OFFICIAL NOTICE OF DECISION

CITY OF ALBUQUERQUE
PLANNING DEPARTMENT
DEVELOPMENT REVIEW BOARD

13. Project # 1002520

RIO GRANDE ENGINEERING agent(s) for JENNIFER SOULE request(s) the above action(s) for all or a portion of Lot(s) 15 & 16, Tract(s) 2, Block(s) 4, **NORTH ALBUQUERQUE ACRES, UNIT 3**, zoned R-D residential and related uses zone, developing area, located on ALAMEDA BLVD NE, between WYOMING BLVD NE and LOUISIANA BLVD NE containing approximately 2 acre(s). [REF: 04DRB00705] (C-19)

**6' PERIMETER SCREEN WALL DETAIL**

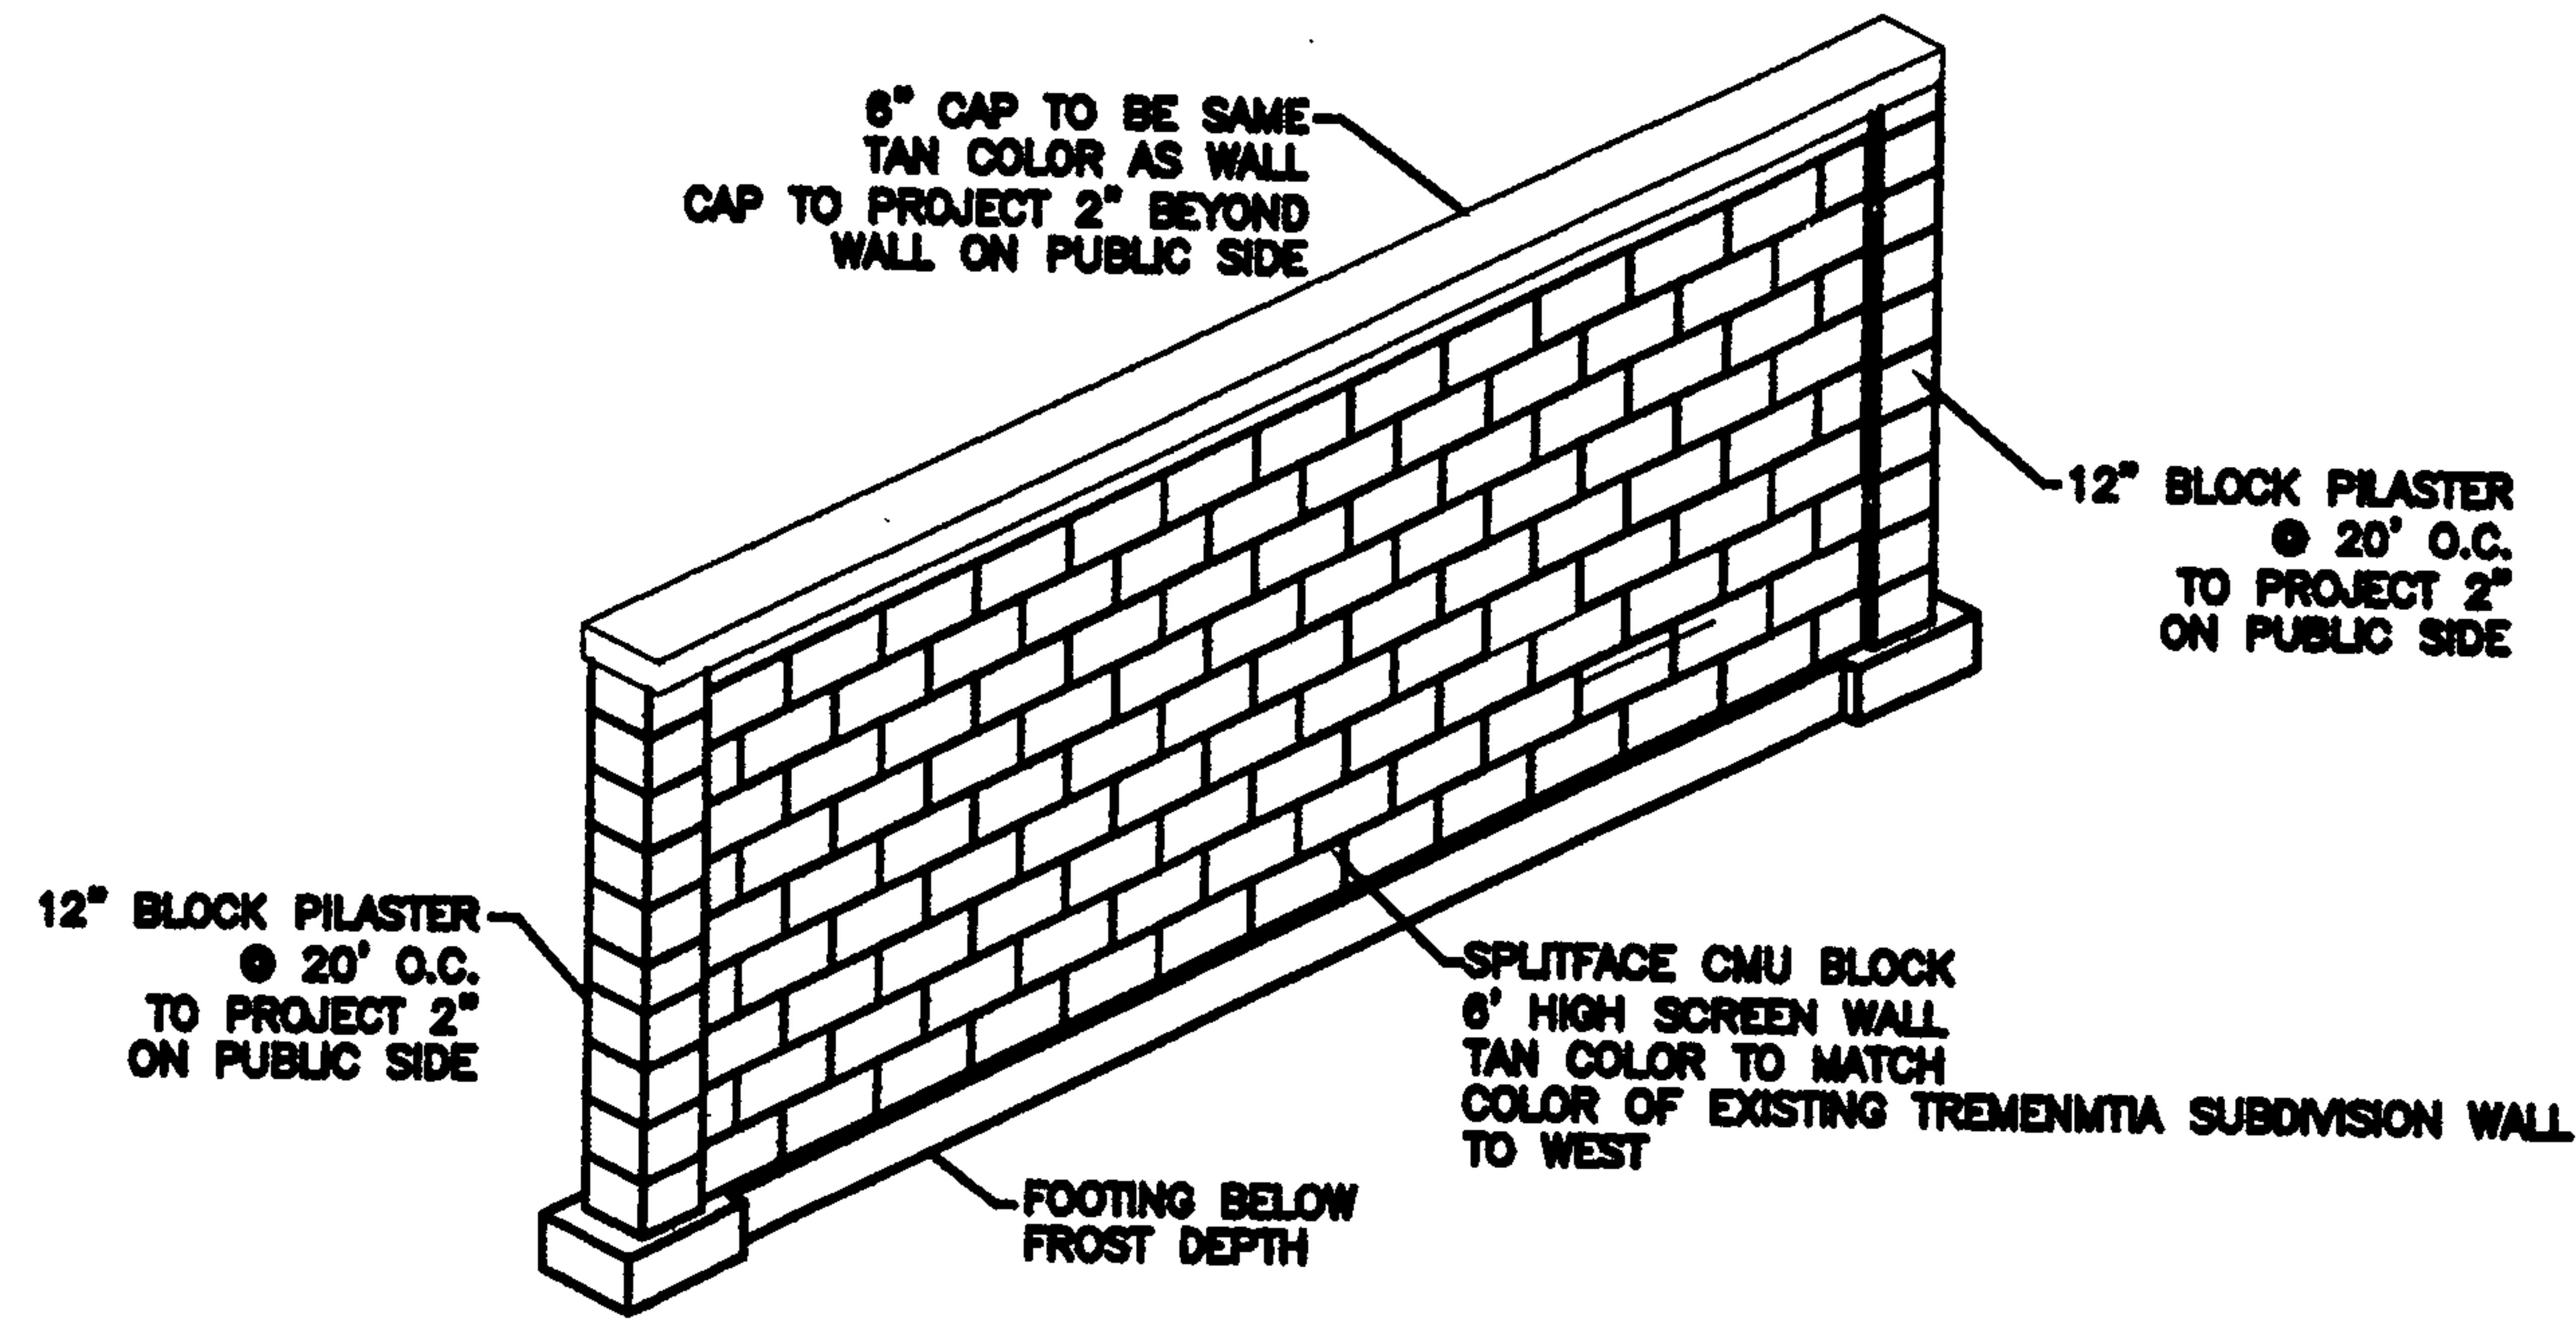
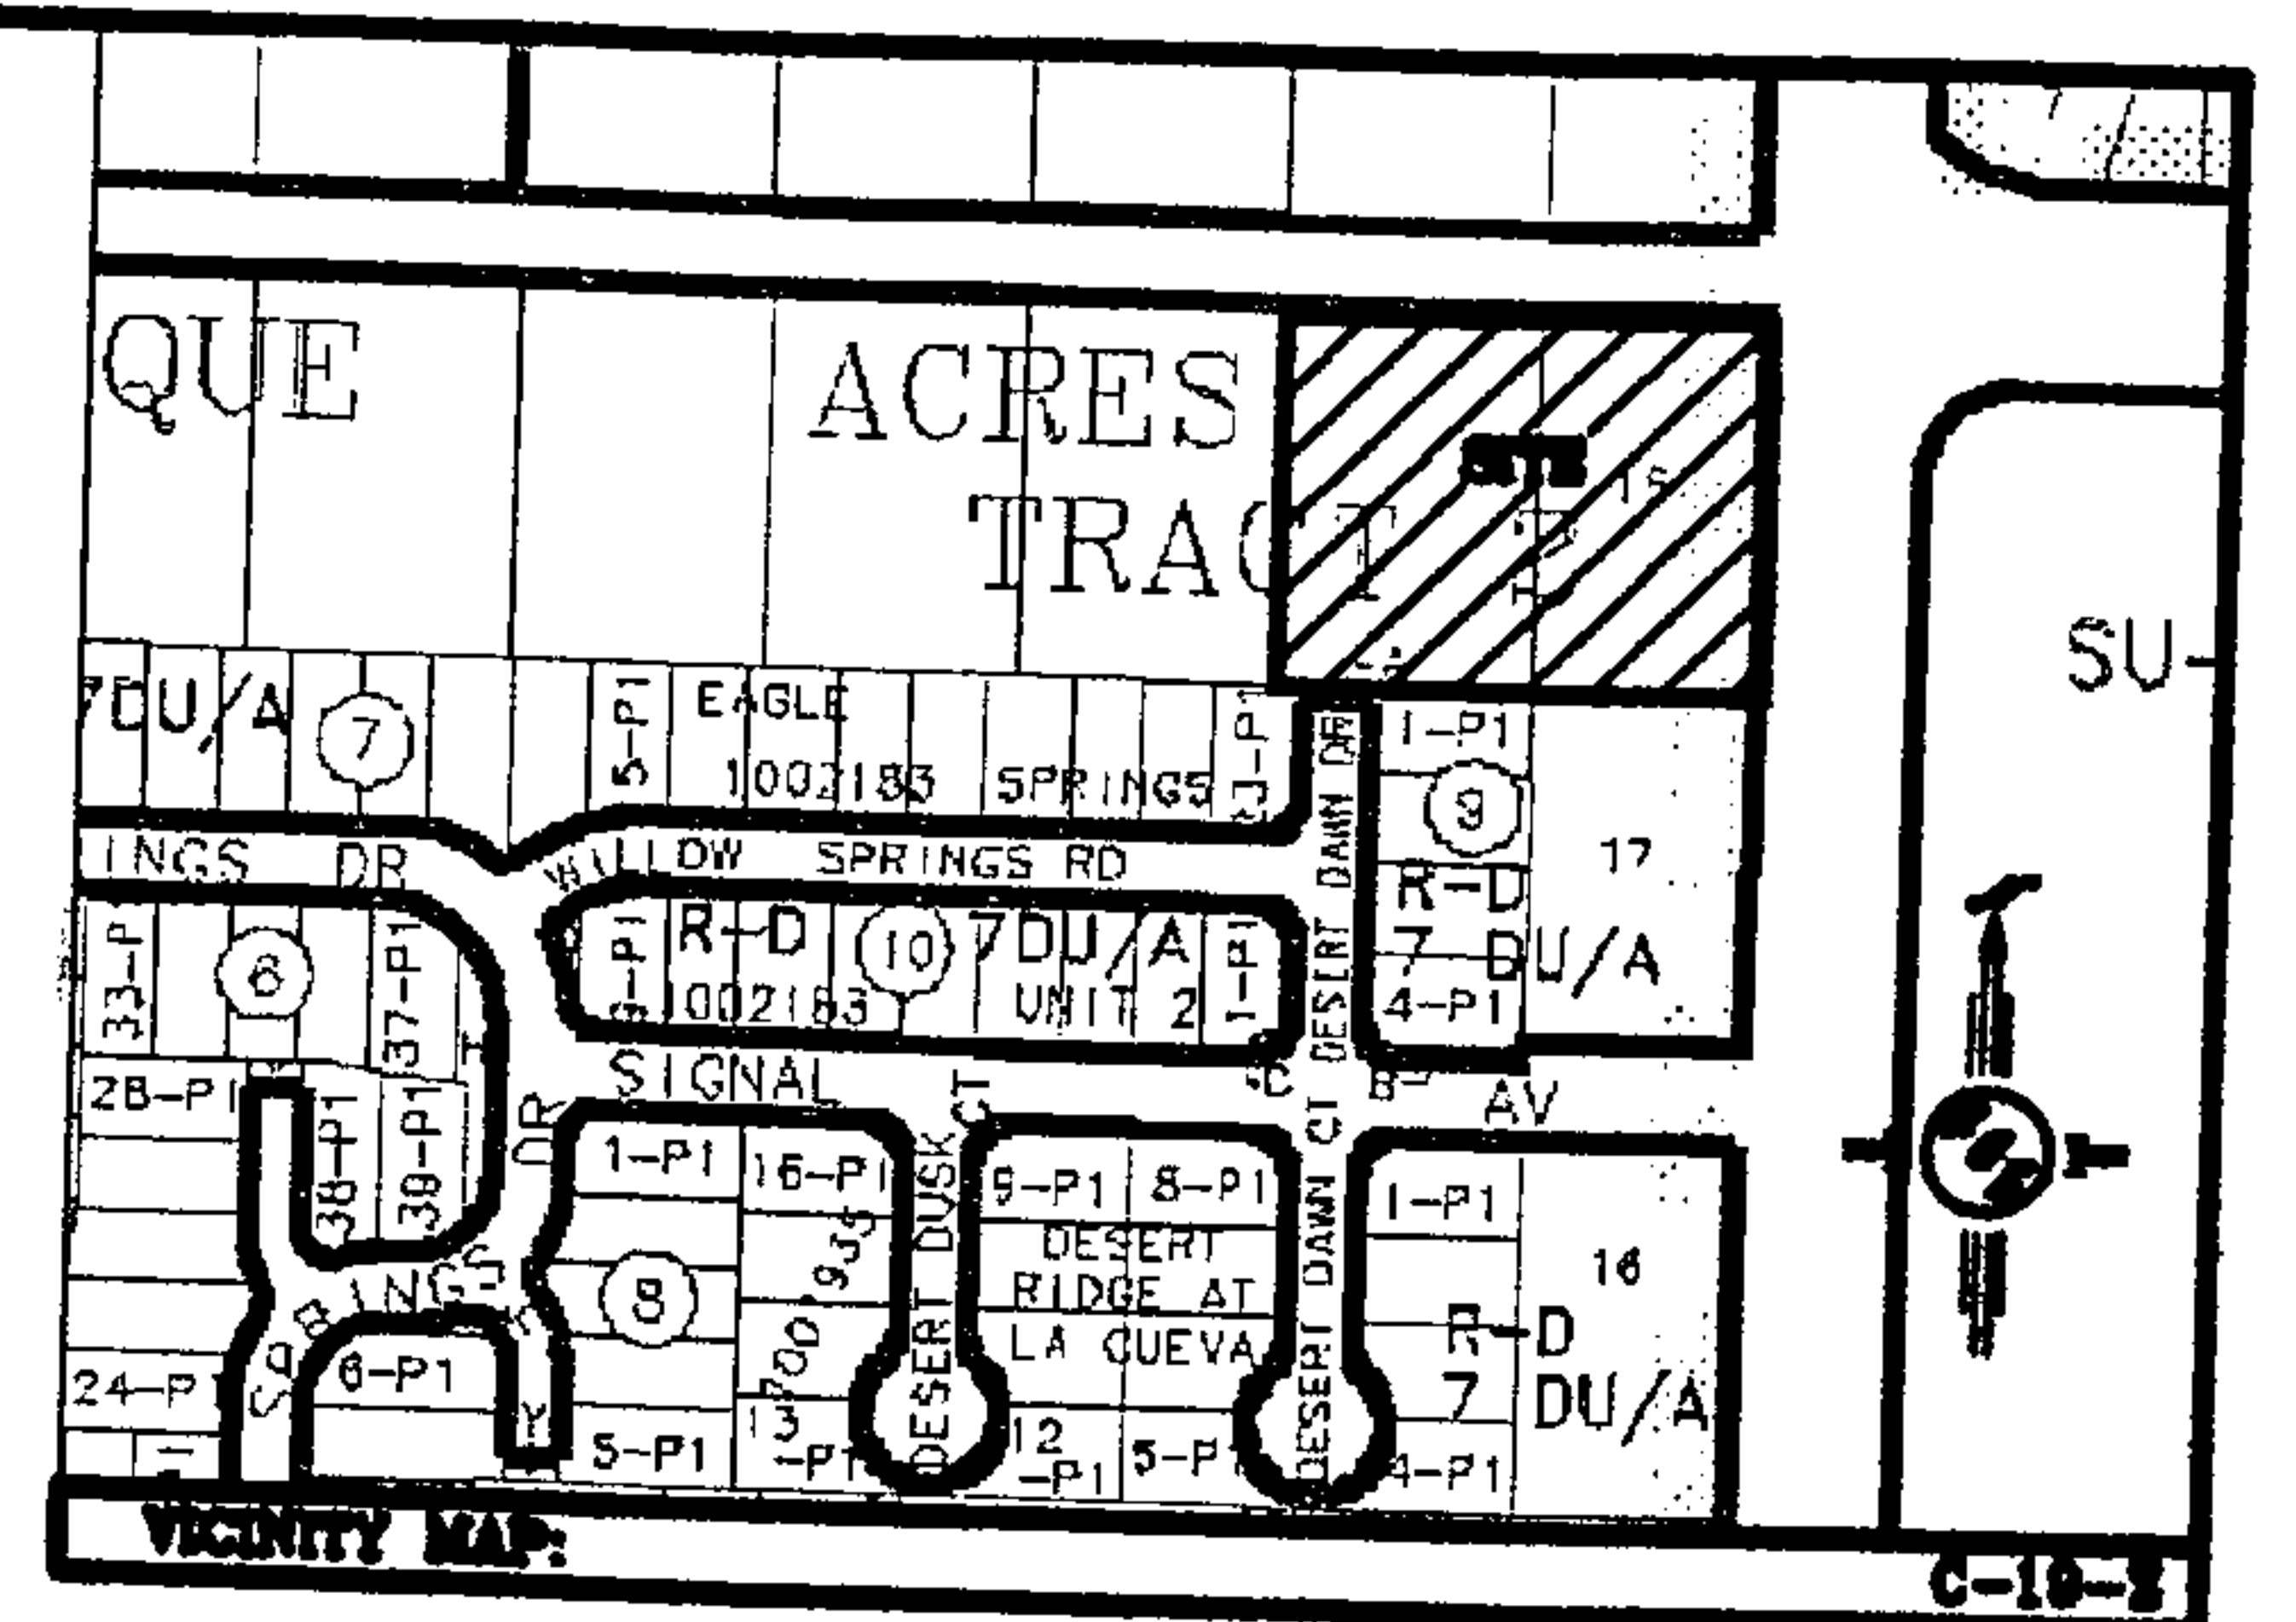
Wall design submittal shall be revised to meet Zone Code requirements.
